Drainage & Highways Reply to LCC
Comments for Development
at Wardentree Lane, Pinchbeck, Lincolnshire
PE11 3UG
Application Ref H14-0720-18

14 May 2021

Drawing:
Planning Site Layout

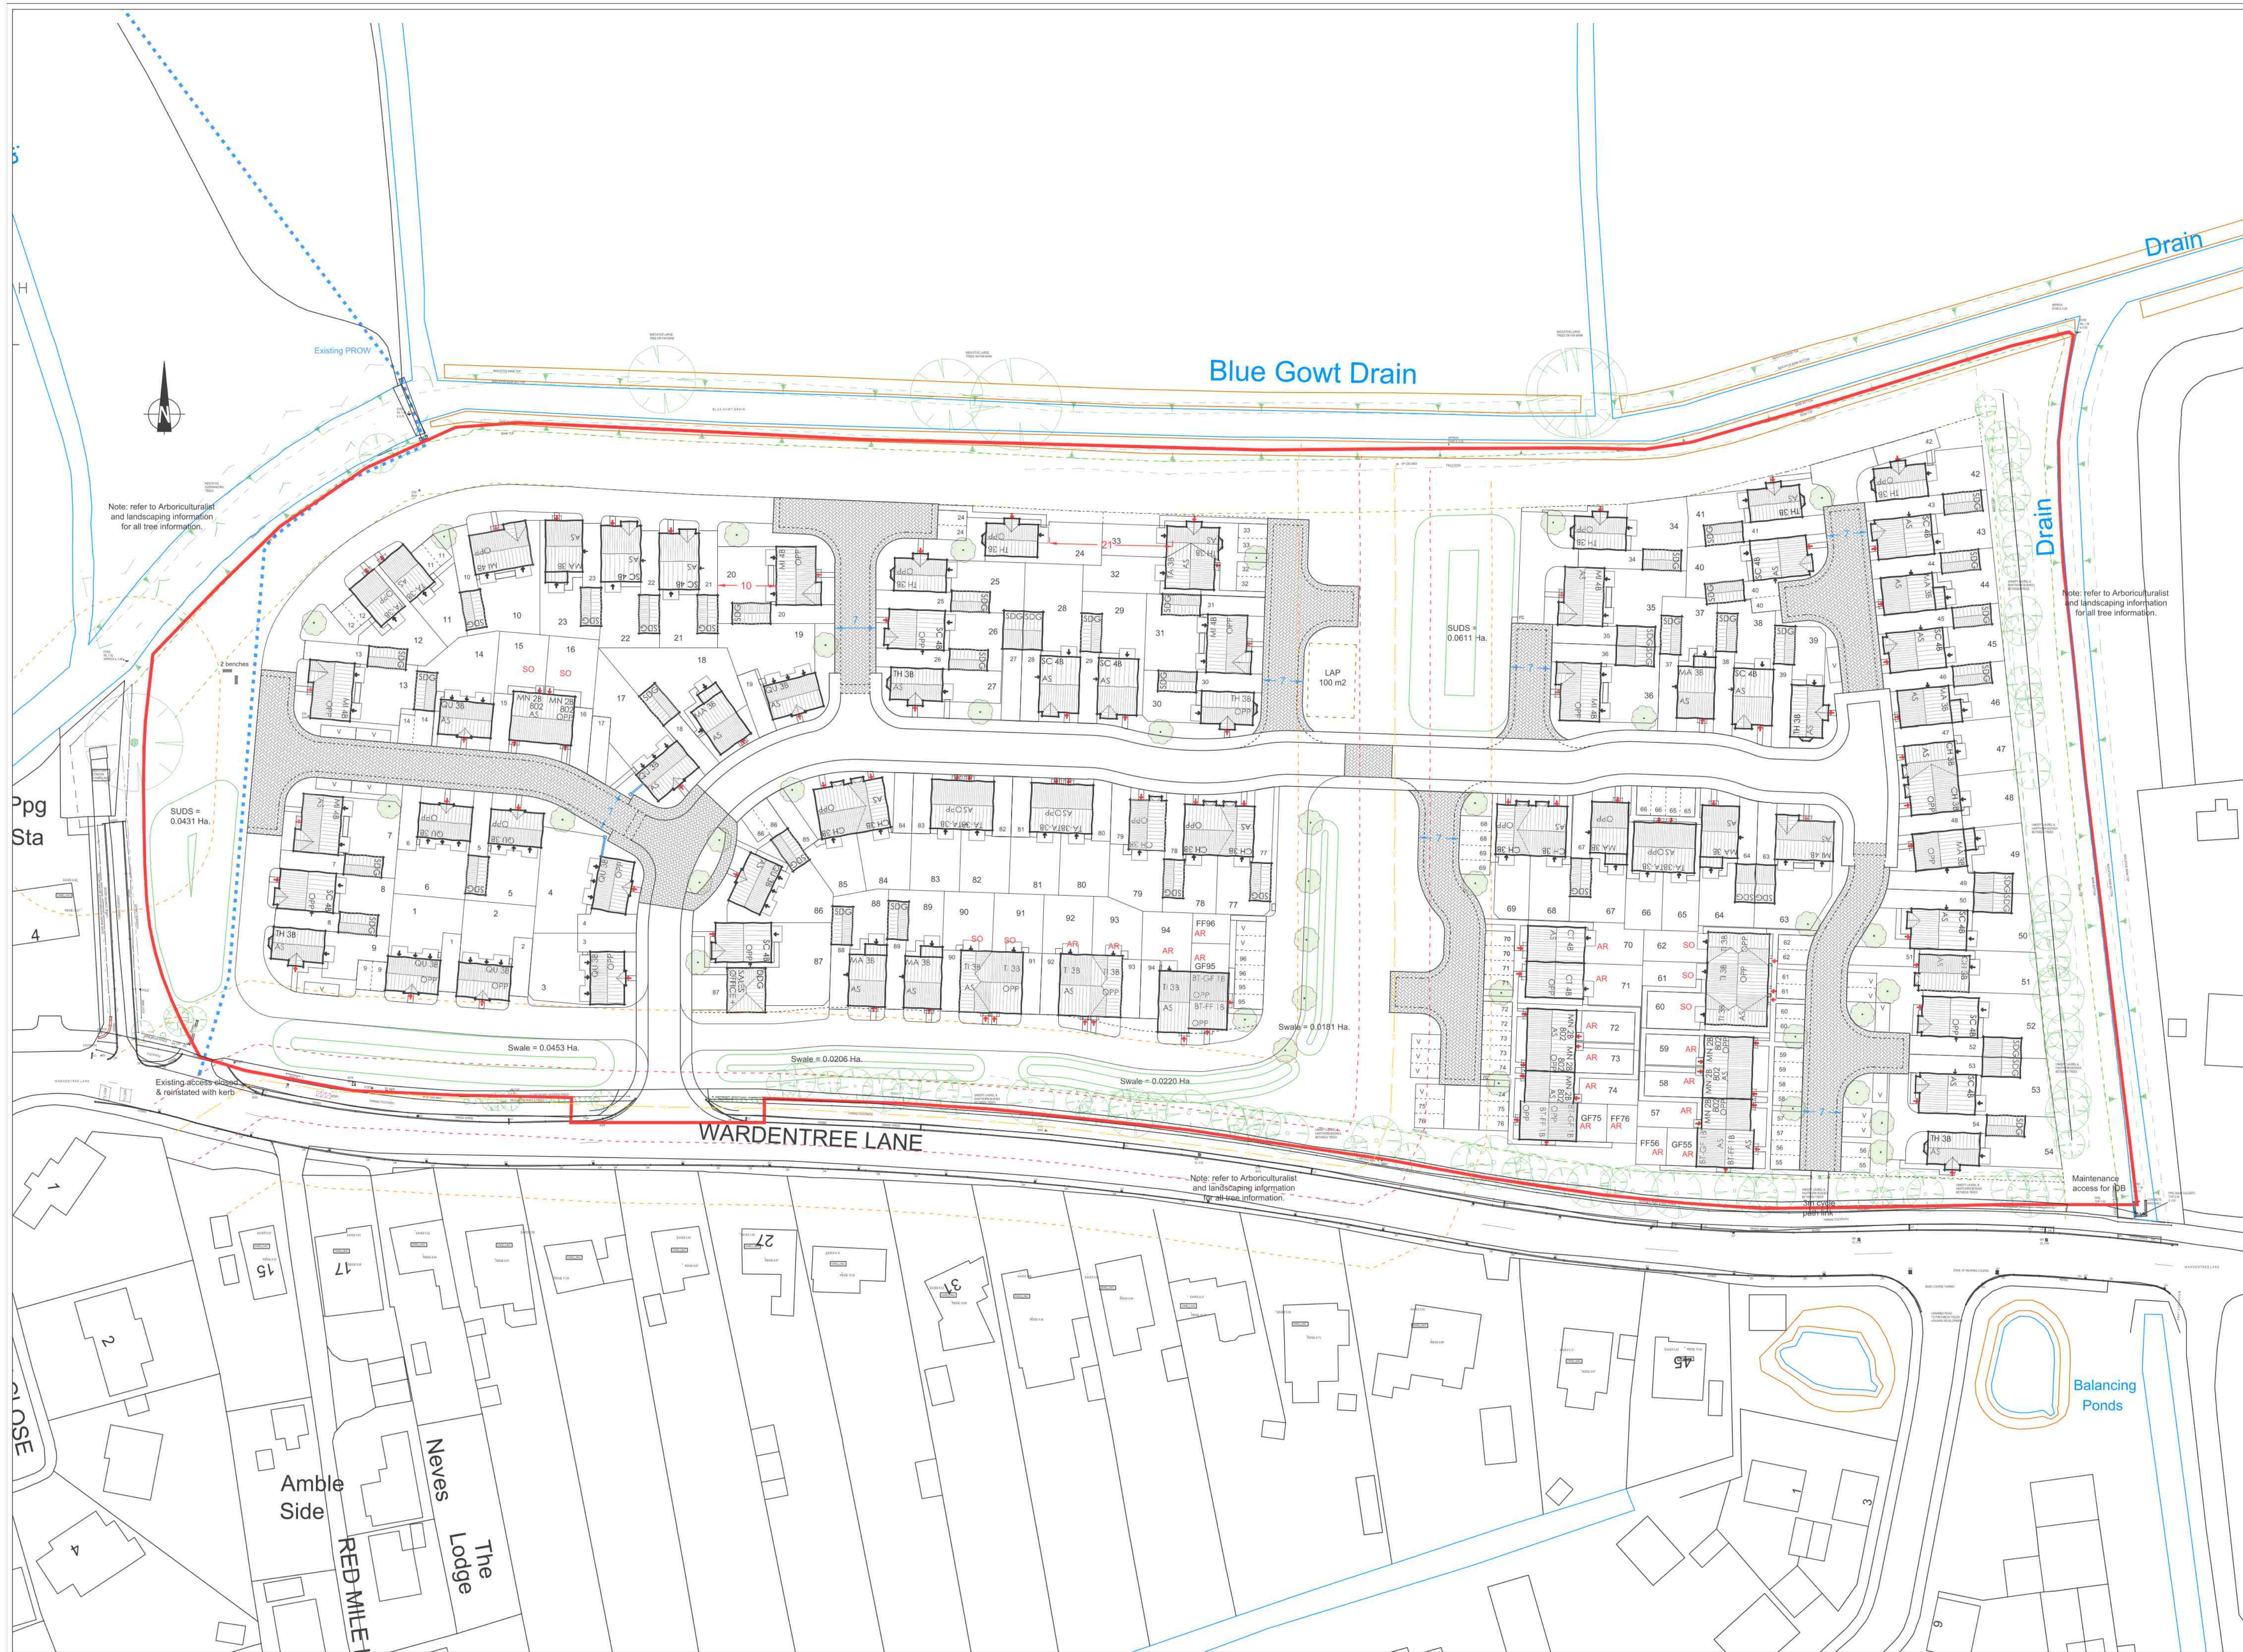
1. There are three proposed cycleway/footway links off Wardentree Lane to the site, one is located to the South-western side that links on to a private drive and the other two are in close proximity of each other on the South-eastern side that links on to private parking courts. These will be problematic in terms of safe movements and control, therefore further consideration is required on more suitable locations.

2. Service margin strips are not required on the proposed adoptable turning head carriageways, however consideration of suitable carriageway width and footways will be required.

3. Further consideration on the private drives is required in order to form adoptable edge lanes.
4. The existing access off Wardentree Lane to the South-western side is to be reinstated back to a cycleway/footway with grass verge and full up stand kerb.

5. Consideration of a carriageway design feature located on the main access road in front of the central POS area, similar to that shown at the first junction with block paving and landscaping.

6. The turning heads appear to be proposed as platform areas, i.e. ramps. This transition needs to be level between block paving and bitmac carriageway surface.

- 1 As can be seen on latest revised scheme the majority of these links have been removed, with only one, directly linked to the adopted road at the eastern end of the site, still proposed as a cycleway/footway link
- 2 Noted and amended.
- 3 This has been considered and awaiting exact details from LCC on requirements for Edge Lane, although the principle is noted and will be utilised where appropriate as shown on the layout.
- 4 We can confirm that this will be undertaken as part of the S278 works for the site.
- 5 Noted and shown on layout.
- 6 Confirm that no ramps are utilised in transition from Block paving to Bitmac Roads.

Drawing:
Open Space Plan

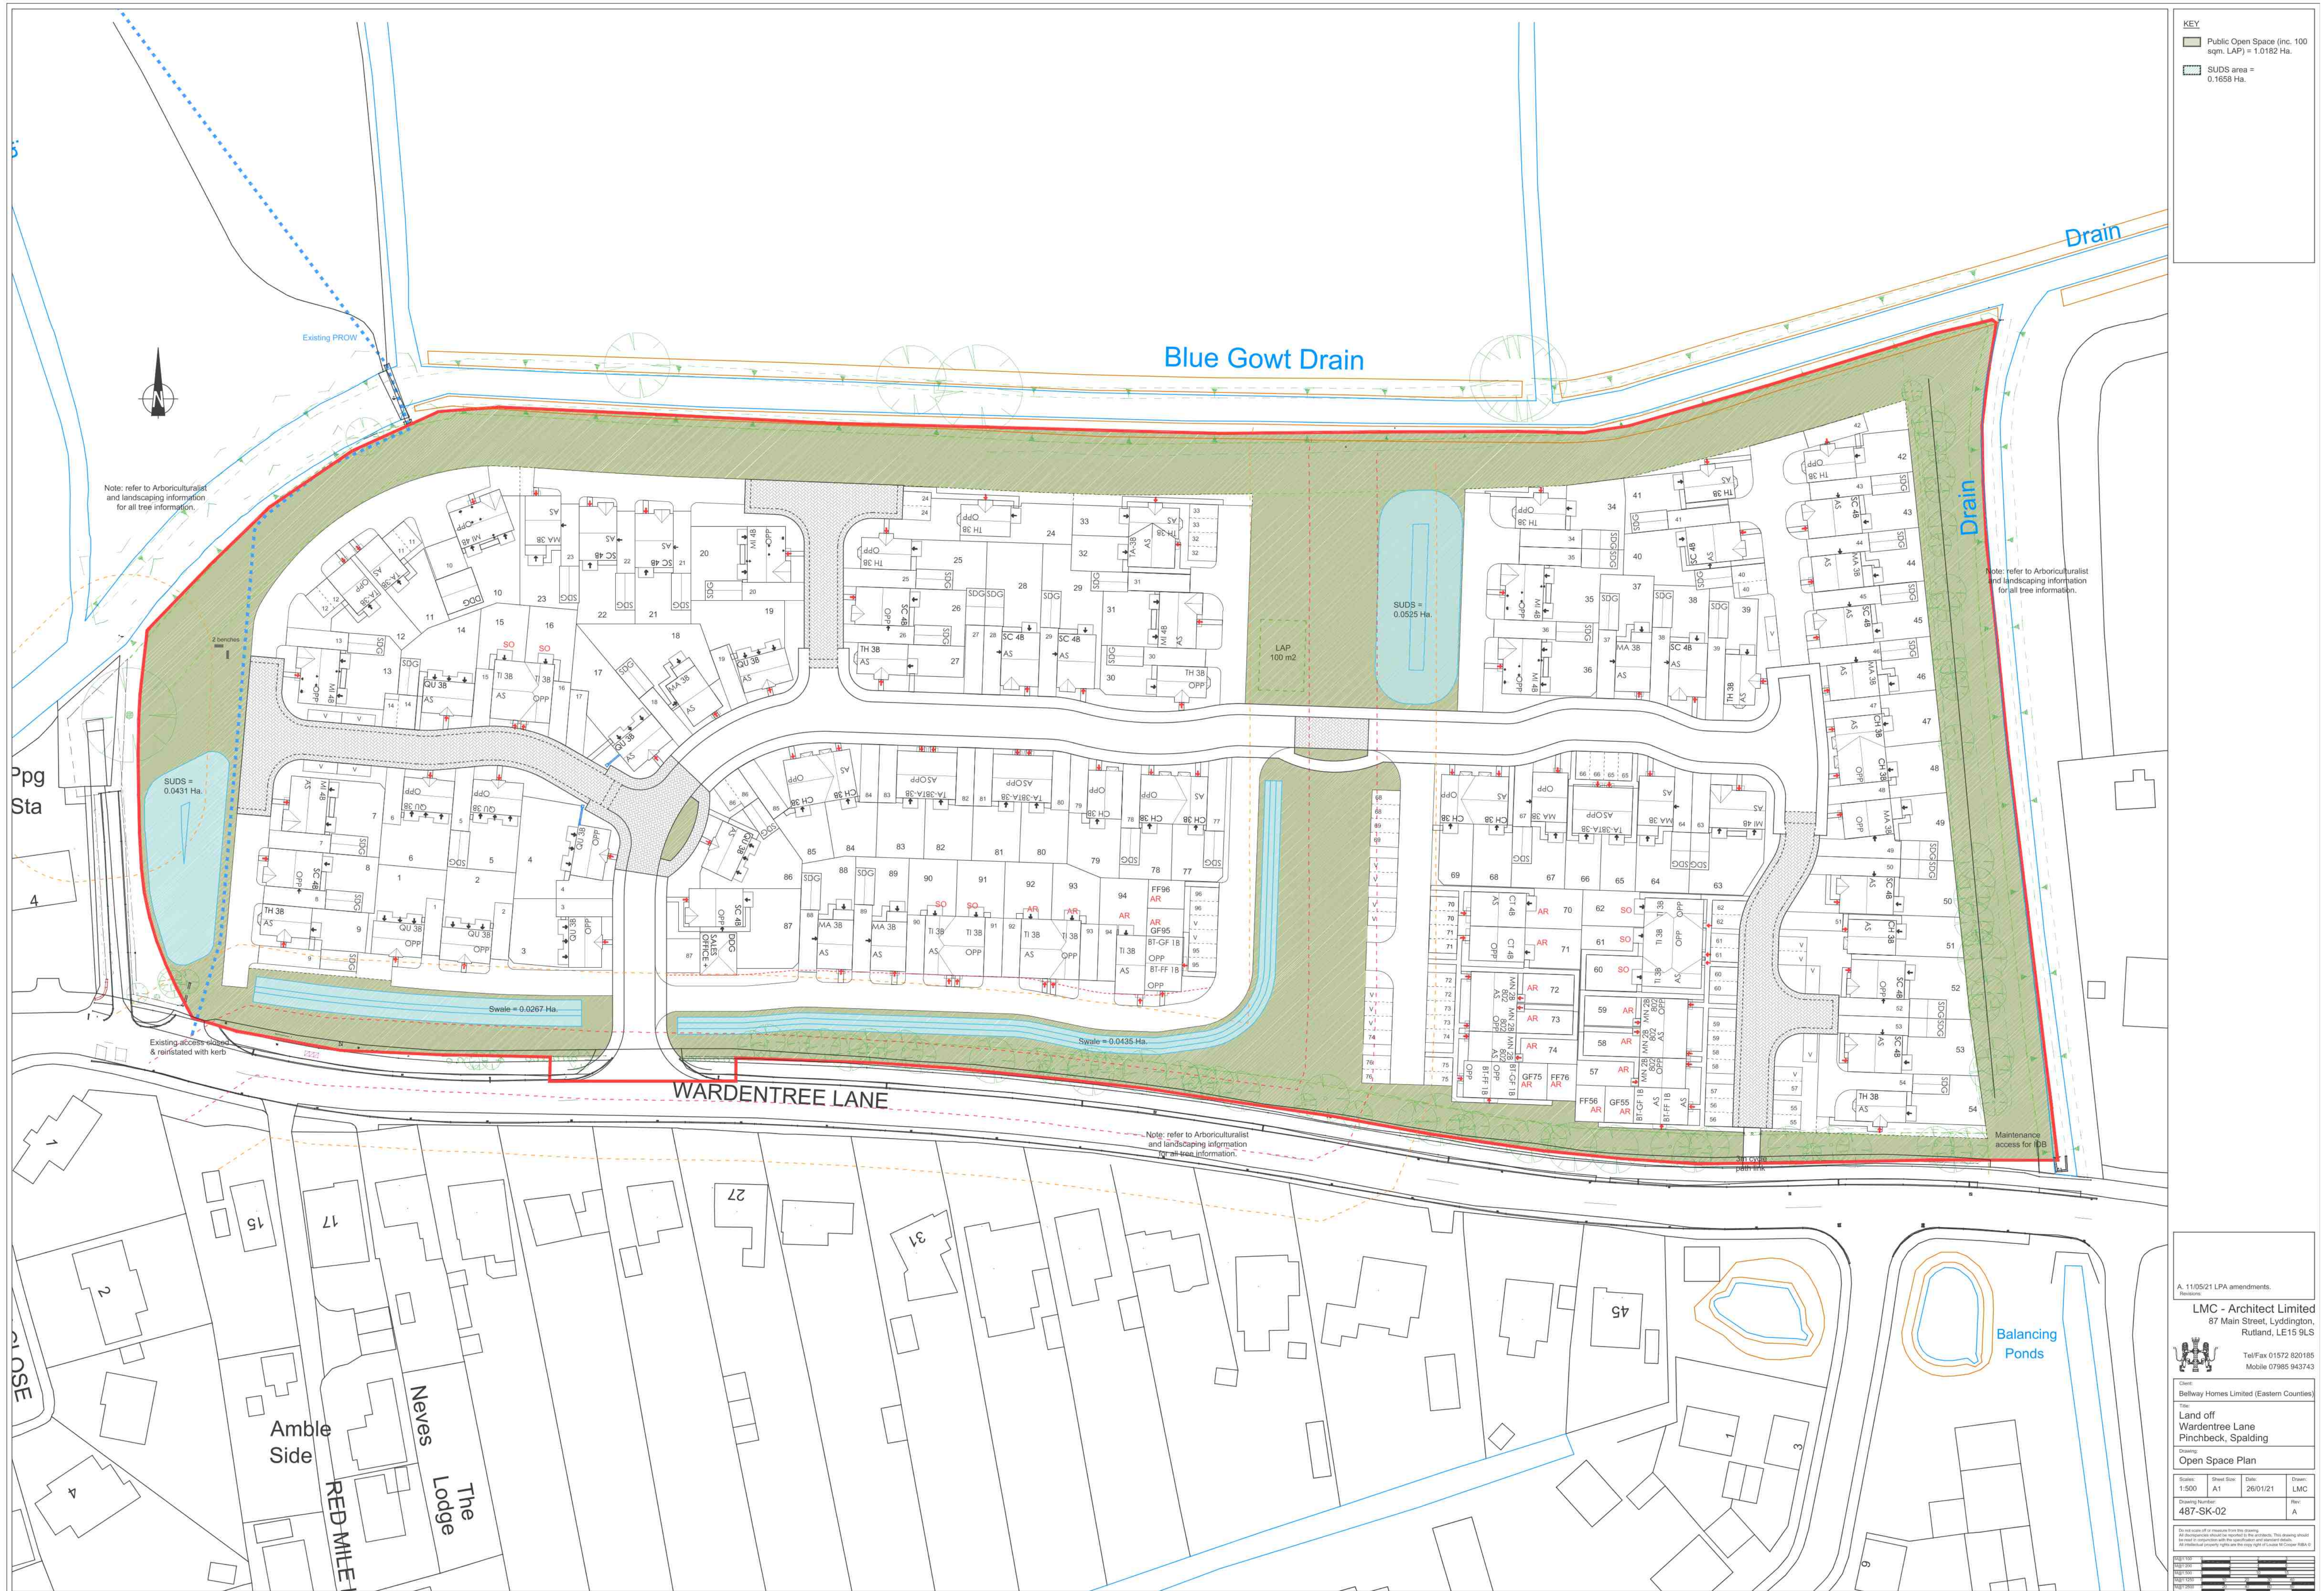
- 1 The section of PF 2 through the site between Wardentree Lane and the footbridge should be surfaced to adoptable standard. This should be separate to the roadside footway.
- 2 It would also be desirable to provide an additional footpath linking the estate to the footbridge in recognition of the likelihood of residents undertaking recreational and utility journeys.
- 3 It is expected that there will be no encroachment, either permanent or temporary, onto the right of way as a result of the proposal.
- 4 The proposed development should not pose any dangers or inconvenience to the public using the right of way.
- 5 Informal footway links through the POS area and IDB'S easement would also be desirable.

- 2 The current ground levels are recorded at 3.5 metres to the North-west corner and 2.6 metres to the North-east corner with FFL's to be set at 3.4 metres, therefore ground levels will have to be raised. That said, it would appear an attenuation basin/pond will be located at the highest point rather than the lowest.

- 1 2 & 5 As discussed at our meeting, it is not possible to pave PF2 within the IDB easement as it could be damaged by IDB maintenance vehicles and the IDB would not take any responsibility for maintenance for footpaths, therefore it would not be appropriate to formally pave any of the footpaths within the open space, however, informal links throughout the POS area and IDBs easement will be encouraged with regard to potential mown areas.
- 3 No encroachment onto the right of way is intended, a formal application for temporary works will be made at the appropriate time by the Developer.
- 4 Noted and agreed.

- 2 The site is being raised generally to the east but in affect all over to assist with drainage of the site, both foul and Surface water. This is primarily due to the existence of a gas main running through the middle of the site, which will discuss in more detail later, This has meant that the site is split into two for surface water drainage hence two attenuation basins; this also explains;
